Engineering Review
04/16/2020 3:51:17 PM
dsdrice
JeffRice@elpasoco.com
(719) 520-7877
EPC Planning & Community
Development Department

RE: River Bend Crossing
City of Fountain, Colorado
Updated Traffic Impact and Access Analysis
LSC #184140

LSC Responses to PCD TIS Redlines dated April 16th 2020

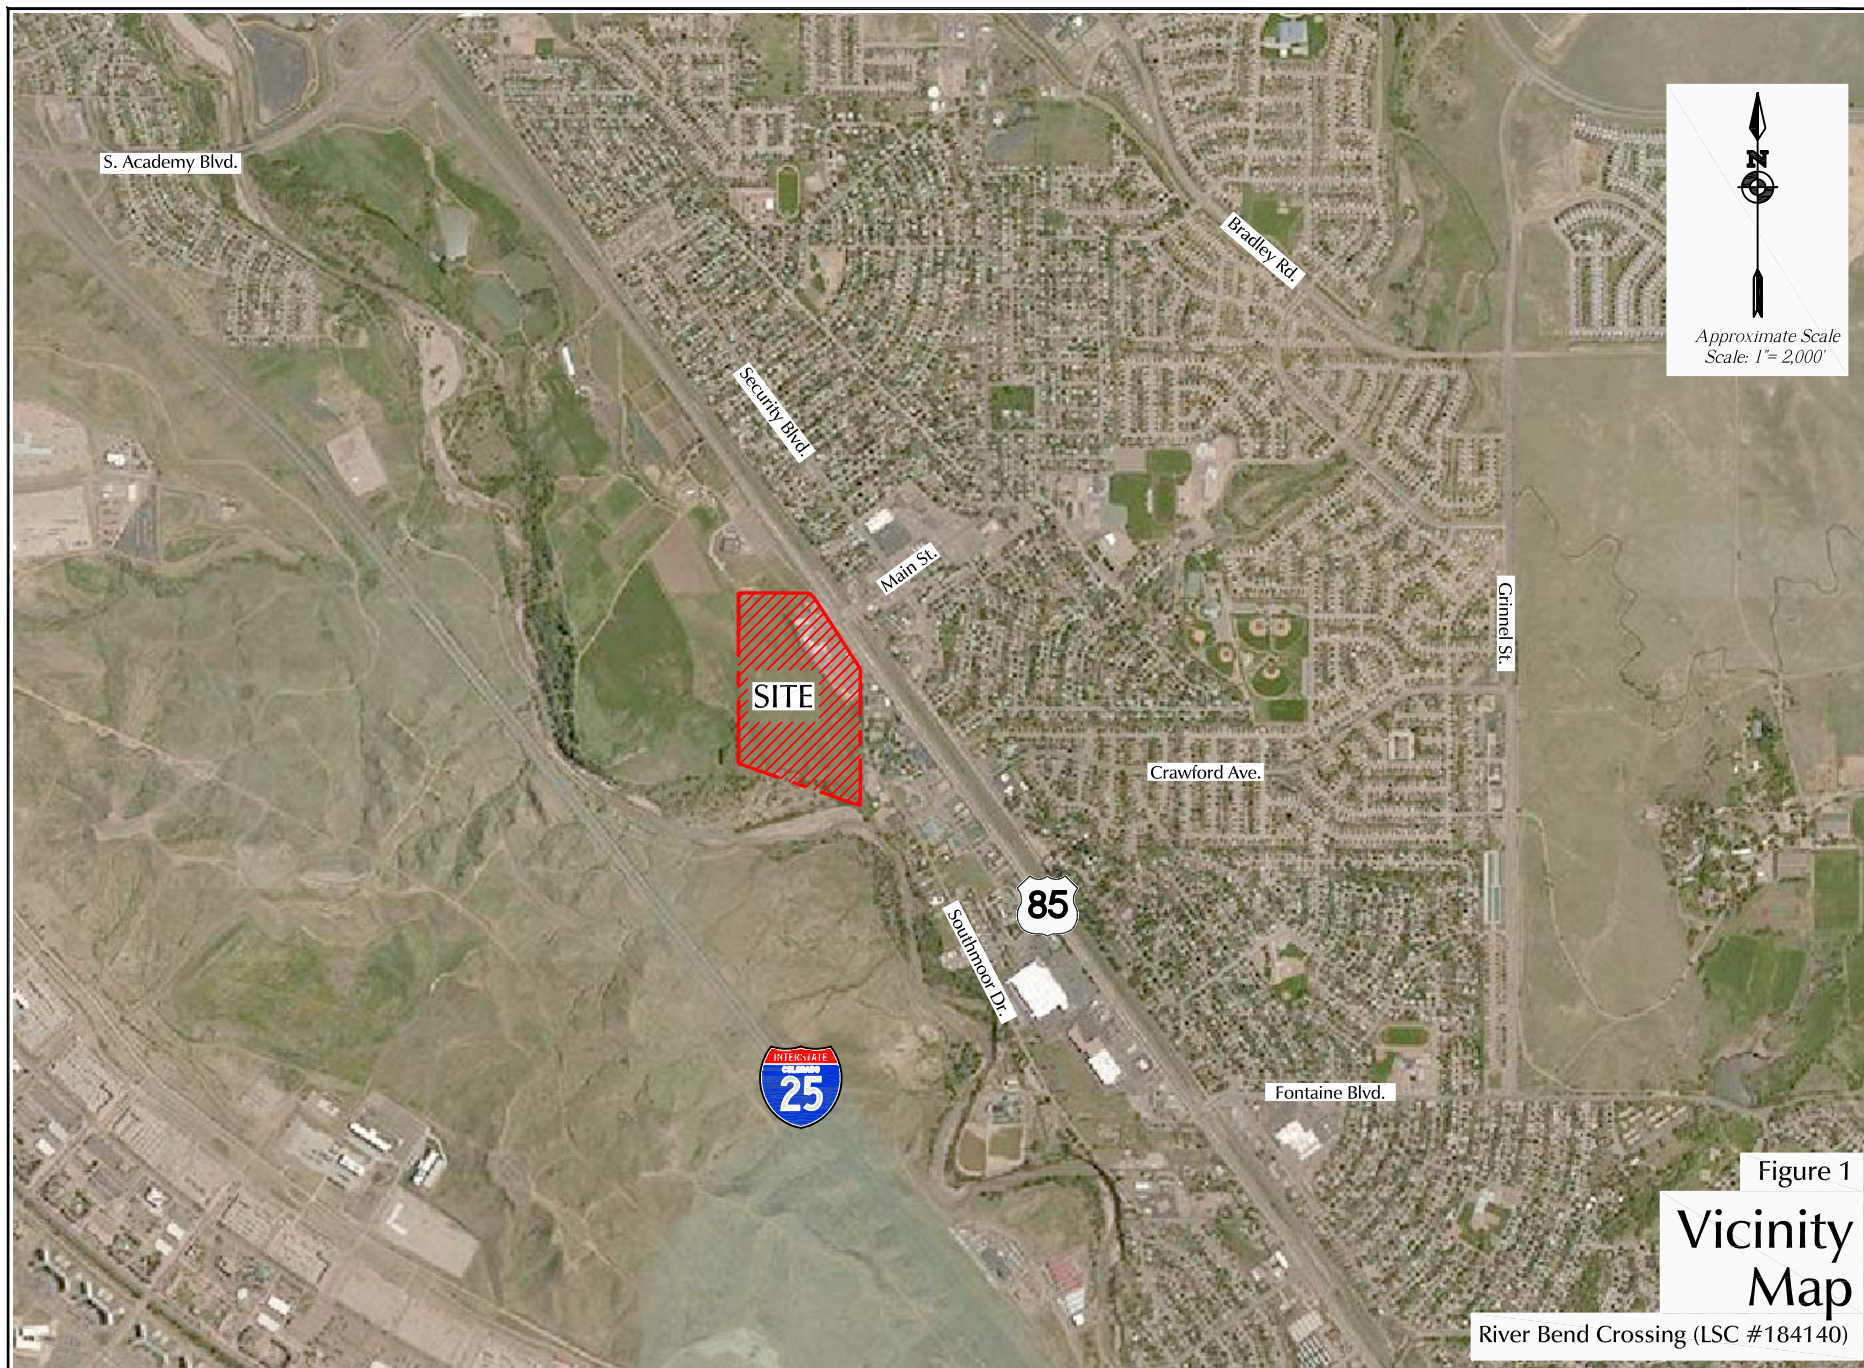
northwest

northwest

↩ Author: jchodsdon Subject: Sticky Note Date: 8/17/2020 12:14:23
LSC Response: Corrected as requested.

Figure 3

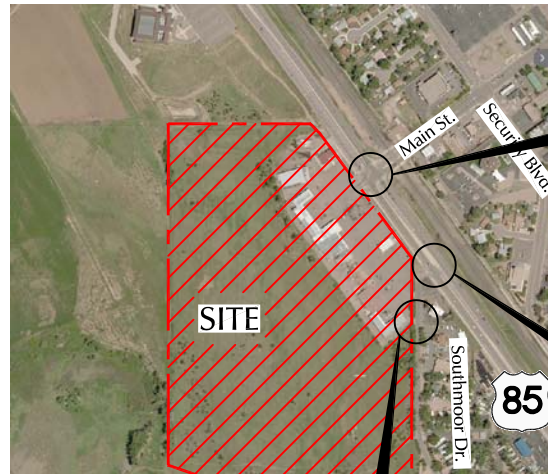
75? 4

520? 3

520?

75?

↩ Author: jchodsdon Subject: Sticky Note Date: 8/17/2020 12:15:21
LSC Response: Corrected as requested.

↩ Author: jchodsdon Subject: Sticky Note Date: 8/17/2020 12:16:20
LSC Response: Added as requested.
